SSD-79316759
45-53 Macleay St, Potts Point
Exhibition “Have your say”

After reviewing the submission, as an owner/occupier in neighbouring building, 12-16 Challis Avenue, I have the following 5 points of feedback:

Drawing Name
FLOOR PLAN L3

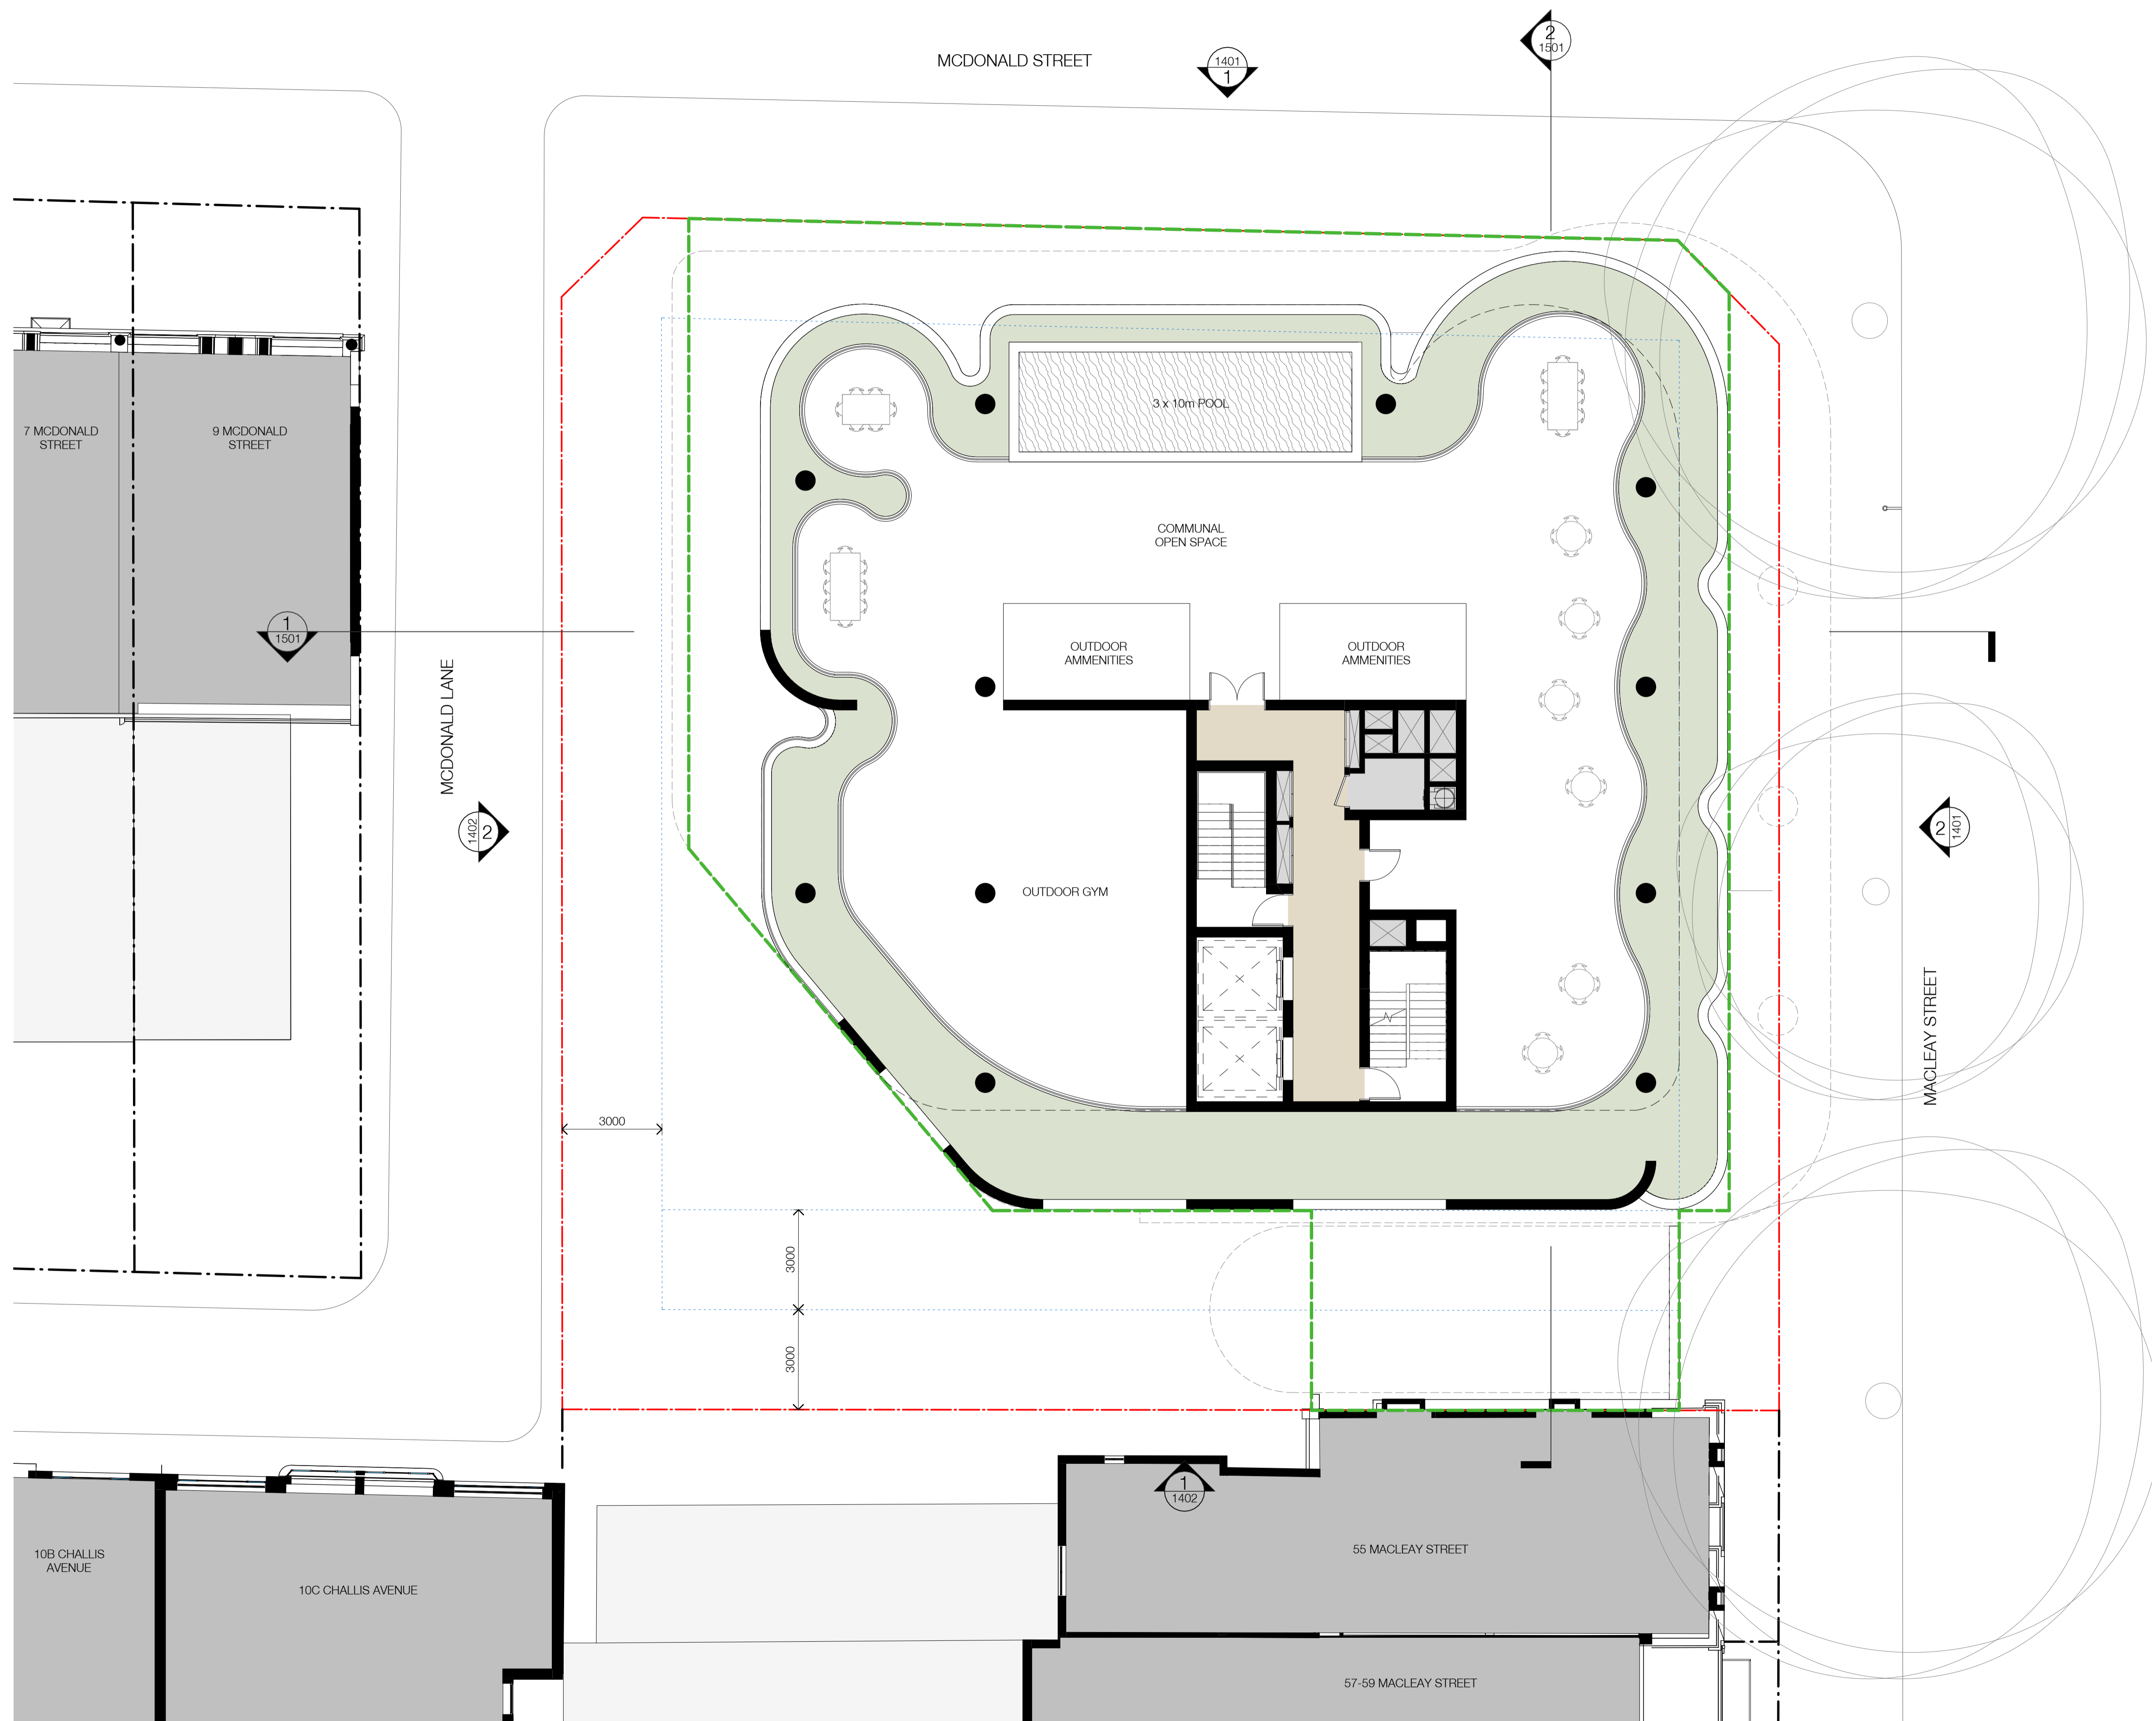
1) The concept architectural drawing provides an “Open Common Area” on level 3 with outdoor gym, outdoor pool, social tables, etc, open on all sides of the building to surrounding residential buildings. This open common area, at it’s proposed height, and the use thereof, severely impacts upon surrounding resident’s privacy and will echo noise day and night. Individuals and groups will be able to easily peer into all surrounding residential building’s levels 1, 2, 3, and 4.

A counter-proposal is to move all amenities from this open common area to ground floor or basement. If the argument is that moving it would not provide enough sunlight, well, this entire proposed building will take away direct and indirect sunlight from all surrounding residents.
